CITY OF ALBUQUERQUE

August 16, 2022

**Re: Bernalillo County Regional Recreational Complex Development
Traffic Impact Study**
Engineer's Stamp dated July 14, 2022 (R15D002)
Received 7/14/2022
CABQ Planning Transportation approval

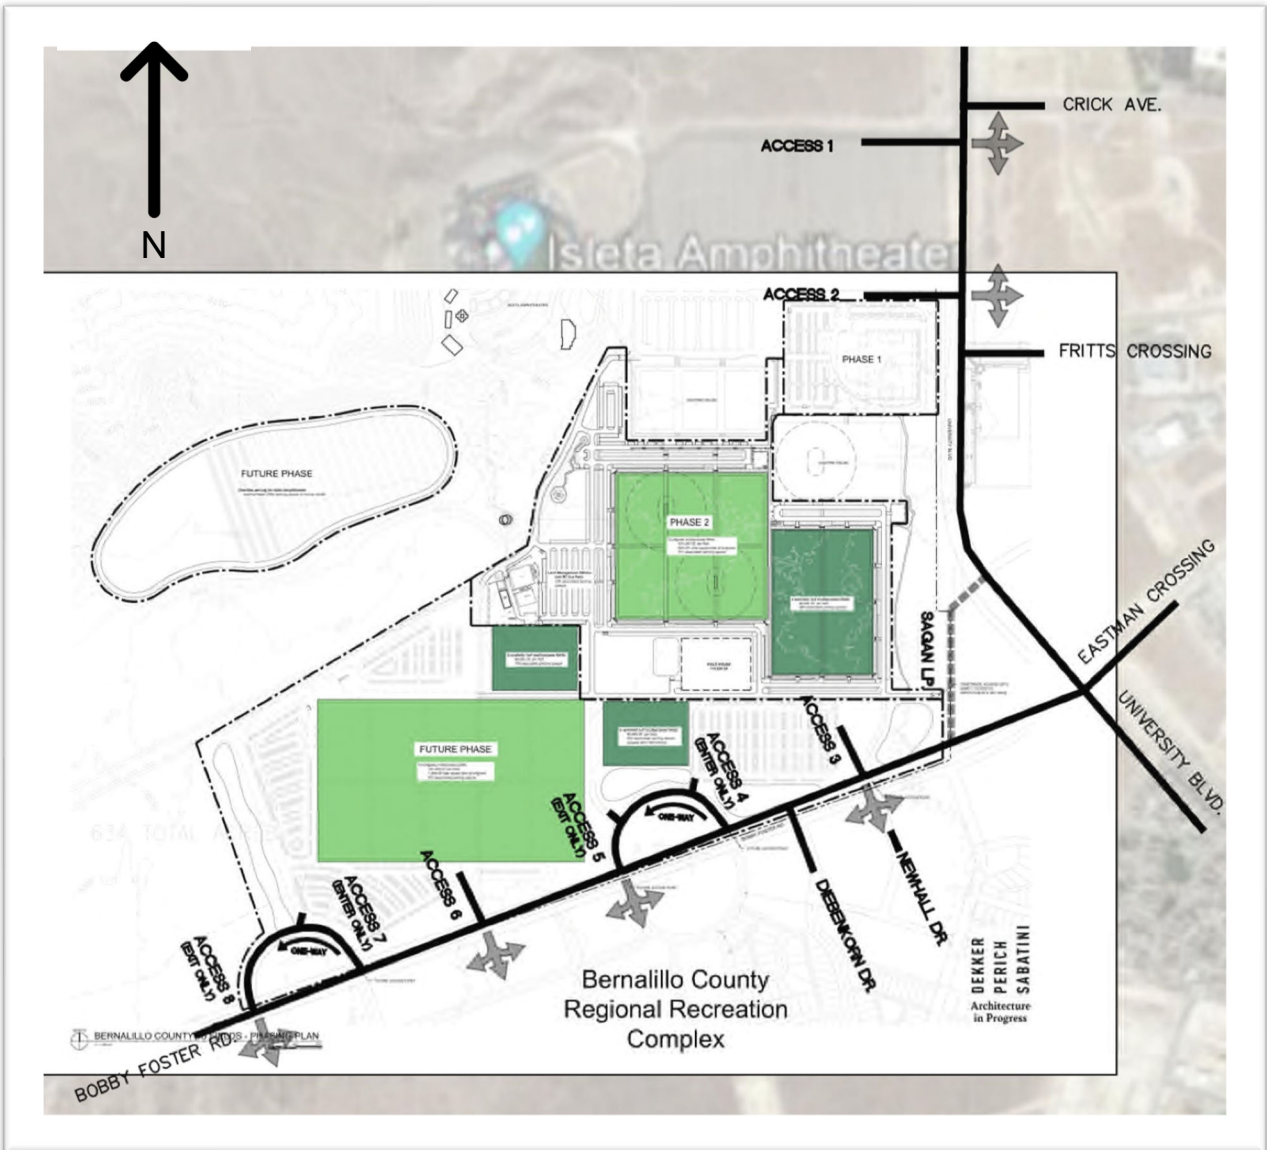
1. Intersection 1 – Access 1 & University Blvd.

- 2026 –
 - Crash rates due to conflicting movements are expected to be low, however, if crash rates become excessive as traffic volumes increase, Access 1 should be restricted to a right-in/right-out/left-in only driveway until Access 1 can be aligned with Crick Ave.

- 2036 –
 - Relocate Access 1 to align with Crick Ave when Valle del Sol, the development north of the MDSTF, is developed.
 - 2. Intersection 2 – Access 2 & University Blvd.

- Eliminate access to Bobby Foster Rd. from Access 2 since the connection of this roadway to Bobby Foster Rd. further south through Sagan Loop will be closed.

- 2026 –
 - Re-stripe Median north and south of the intersection as a continuous Two-way Left-turn Center Lane (TWLTL) from end of existing TWLTL south of Fritts Crossing to the beginning of the taper for NBL turn lane at Access 1. The TWLTL shall be wide enough to allow for future construction a raised median with left-turn lane bays.

- Construct a southbound right-turn deceleration lane, at least 240-ft long including transition with substantial completion of the MDSTF or with full build-out of University Blvd. as part of the Mesa del Sol Level B Master Plan, whichever is first. Design and construction of the lane should conform to the Full-build concepts presented in MDS Level B Master Plan.

- Special event traffic management. Prohibit access to the center EB exit lane except when a flag-person or police officer is present to control traffic (i.e., during larger events).

- 2036 –
 - When Access 1 becomes aligned with Crick Ave. and the Intersection 1 is converted to a roundabout (see Item 7 below), consider using Intersection 1 as the main entrance to the MDSTF. If not, consider relocating Access 2 100-ft north to avoid conflicting NB and SB overlapping left turns entering Fritts Ave. and Access 2

- 3. Sagan Loop
 - Close temporary access from MDSTF to Sagan Loop and re-route traffic to Access 3 and/or Access 4.
 - 4. Intersection 4 – Bobby foster Rd. & Access 4

- 2026 – Construct a westbound right-turn deceleration lane, at least 240-ft long including transition. Coordinate design and construction of the lane with the planned Bobby Foster Expansion project.

- 5. Intersection 12 – Rio Bravo Blvd. & University Blvd.
 - 2026 – Retime signal and increase queueing capacity of the SBR lane by 150-ft. by extending the existing lane to 300 ft long including transition.

- 2026 –
 - Convert the intersection of Bobby Foster Blvd. & University Blvd from an unsignalized all way stop control to a signalized control based on the full-build concepts for the intersection specified in the MDS Master Plan, Level B. This is an existing problem not made significantly worse by the traffic generated by the development; therefore, this should be a shared cost with the other developments in the study area.

- By 2036 or when Valle del Sol is developed,
 - Extend Crick Ave. west. Provide sufficient ROW for a connection to Access 1. Convert the intersection to a roundabout to avoid excessive delays on the minor approaches and increase the capacity of the intersection. Since there is no existing ROW on the Valle del Sol property to construct Crick Ave. west of University Ave., additional ROW would need to be dedicated by the owners of Valle del Sol for the new roadway and MDSTF will likely be required to share the cost of this project. Also, a second left-turn eastbound lane, traffic signal, and roundabout should be considered at that time to improve the LOS and provide additional capacity for future development.

- 2036 –
 - Consider signaling the intersection to avoid excessive delays for westbound left turning traffic. The development contributes only 2% of the traffic volume to this intersection and as such, should have financial responsibility limited to only 2% of the cost for this solution.

- Align future access points on Bobby Foster in the vicinity of the MDSTF with MDSTF driveways and ensure that the new intersections do not introduce overlapping left turns.
